RE: ENGINEER CERTIFICATION FOR HENDERSON CONSTRUCTION COMPANY  
(L21-D33) CERTIFICATION STATEMENT DATED 1/12/94.

RE: REVISED DRAINAGE PLAN FOR HENDERSON CONSTRUCTION (L-20/D33) REVISION  
DATED 8/23/93.

RE: DRAINAGE PLAN FOR AN ADDITION TO HENDERSON CONSTRUCTION COMPANY  
SITE (L20-D33) ENGINEER'S STAMP DATED 4/5/93.

GRADING & DRAINAGE PLAN NEW MANUFACTURING BUILDING HENDERSON CONSTRUCTION

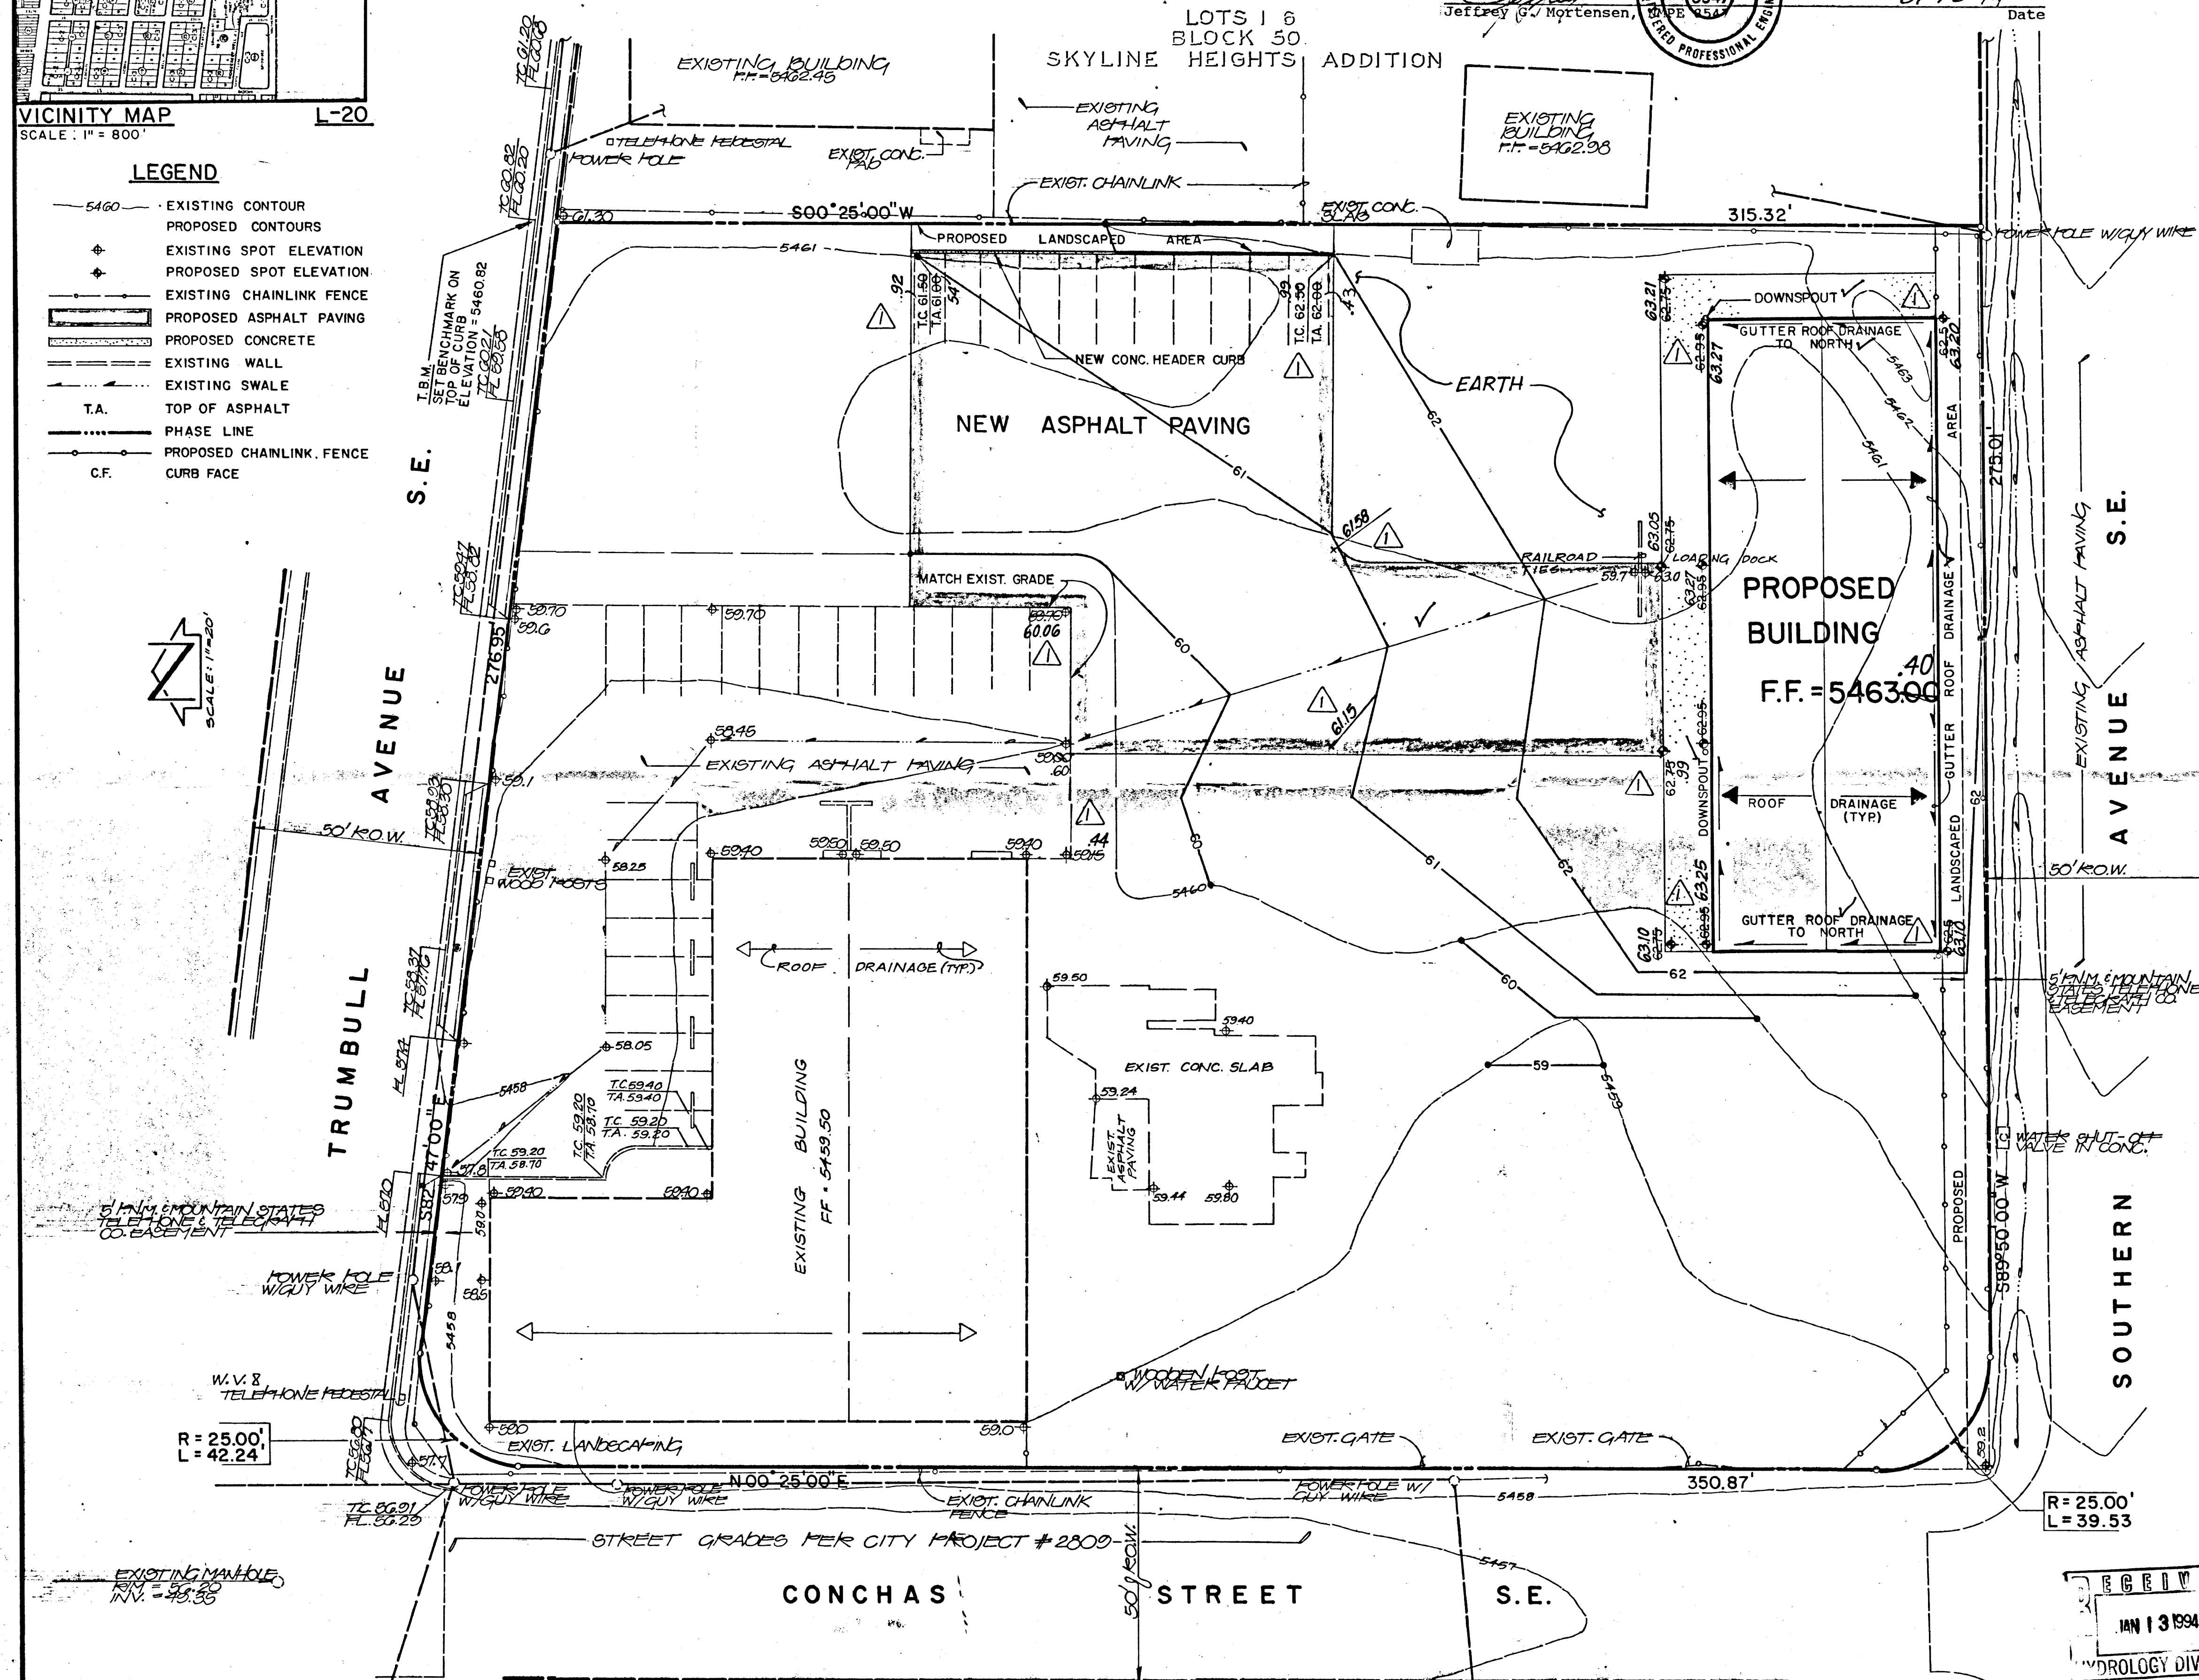
Please be advised that all the new developed runoff from the proposed building must be routed onto the proposed asphalt area.
